from
**Southern
Water**

Our ref
DSA000007295

Proposal: Approval of reserved matters following outline planning permission AL/21/20/OUT for the approval of the appearance, layout, scale and landscaping for 5 No 4-bed dwellings, 14 No 3-bed dwellings & 19 No 2-bed dwellings. This site is in CIL Zone 3 and is CIL Liable as new dwellings.

Site: AL/141/21/RES: - Land North of Lee's Yard, Lidsey Road, Woodgate, PO20 3SU.

Drawing Name Landscape Strategy

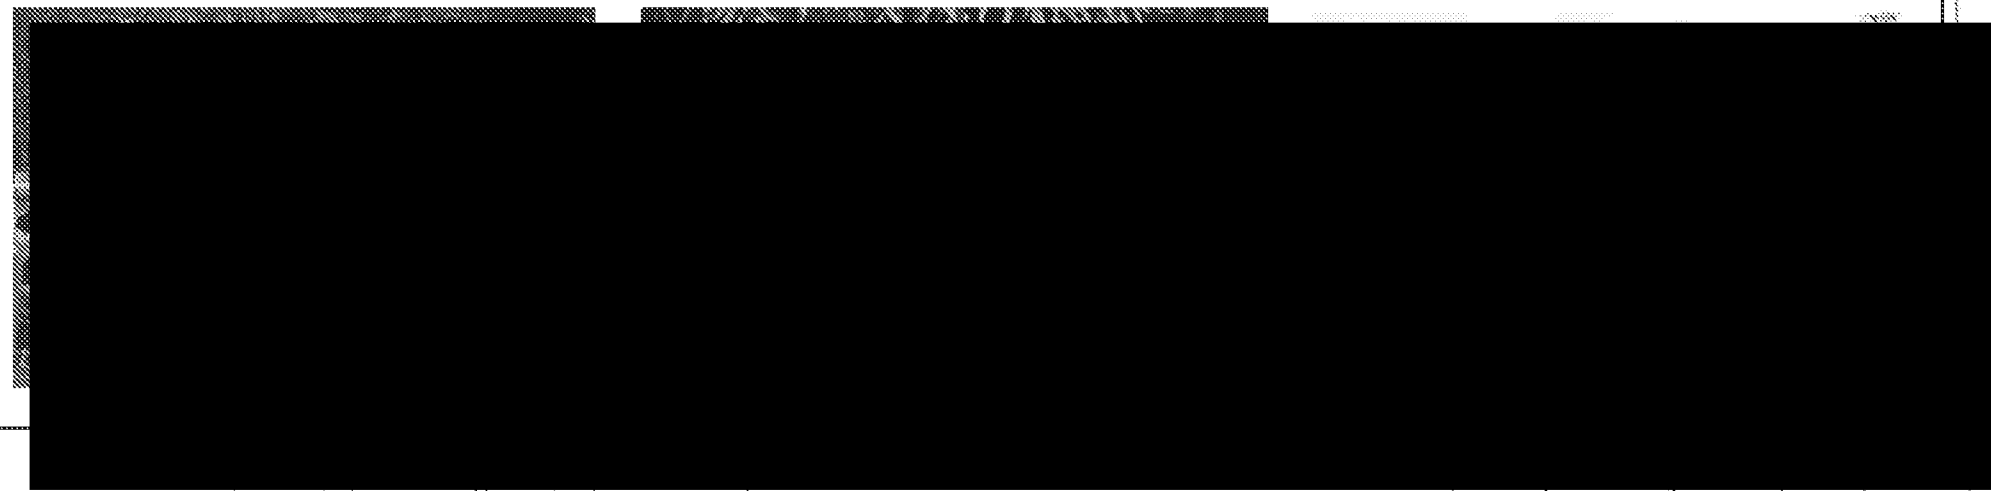
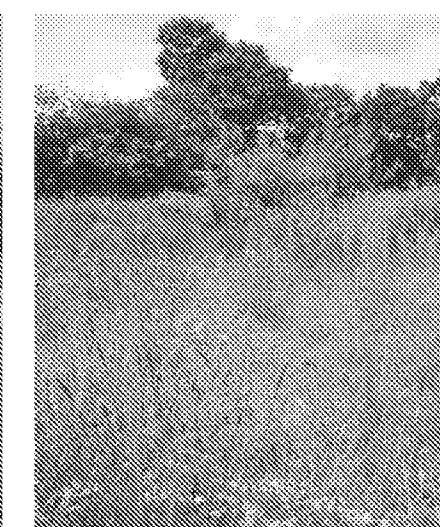
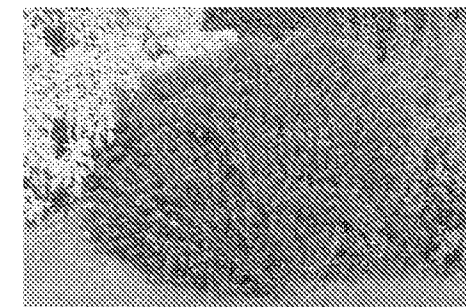
The submitted plans indicates tree planting close to public sewer. We have restrictions on the proposed tree planting adjacent to Southern Water sewers, rising mains or water mains and any such proposed assets in the vicinity of existing planting. Reference should be made to Southern Water's publication "A Guide to Tree Planting near water Mains and Sewers" (southernwater.co.uk/media/3027/ds-tree-planting-guide.pdf) and the Sewerage Sector Guidance (water.org.uk/sewerage-sector-guidance-approved-documents/) with regards to any landscaping proposals and our restrictions and maintenance of tree planting adjacent to sewers, rising mains and water mains.
